Application No: EP/51/20/HH
Site Address: 1 Lashmar Road East Preston BN16 1ES
Description of works: 1.8m wall to front including removal of bushes.

The committee wishes to Object to this Application on the following grounds.

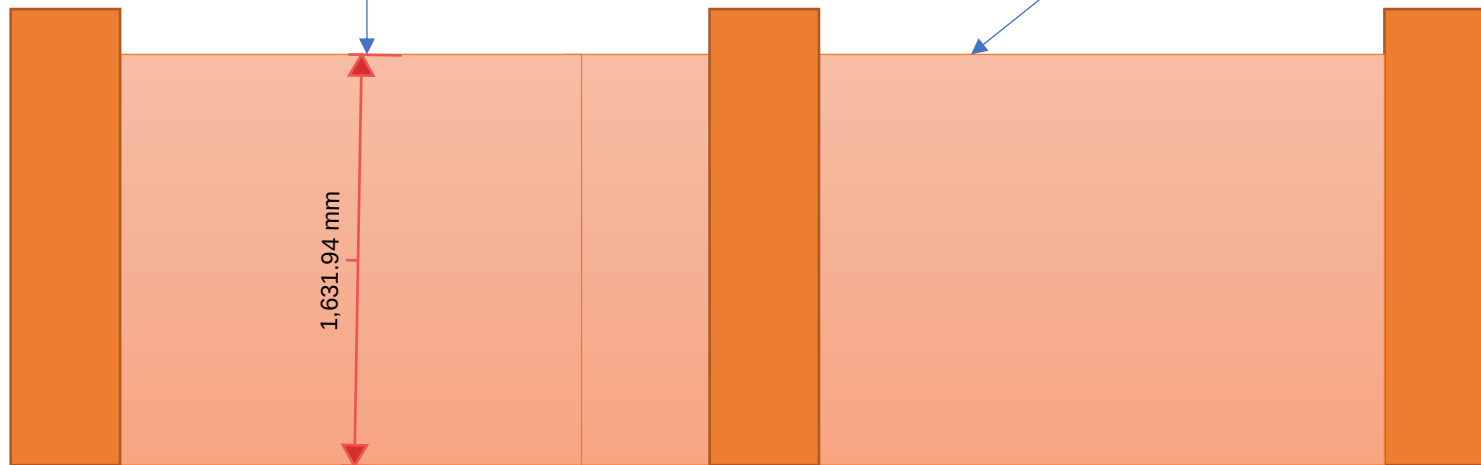
The proposed development is considered to have a significantly harmful impact upon the character of the street scene, and the wider locality, due to its bulky appearance, and significant scale. There are no similar walls in the locality. As such, the proposed development conflicts with D DM1 of the Arun Local Plan, and Policy 2 of the East Preston Neighbourhood Development Plan.

There was also concern about the possibly contradictory information on the plan of the wall. The height arrow on the wall suggests the wall will be 1.63m high, yet the info box above the wall says it will stand 6ft from the pavement. 6ft is 1.83m. If the wall is standing 1.83m, then with pillars and any pillar decoration will be considerably above 6ft.
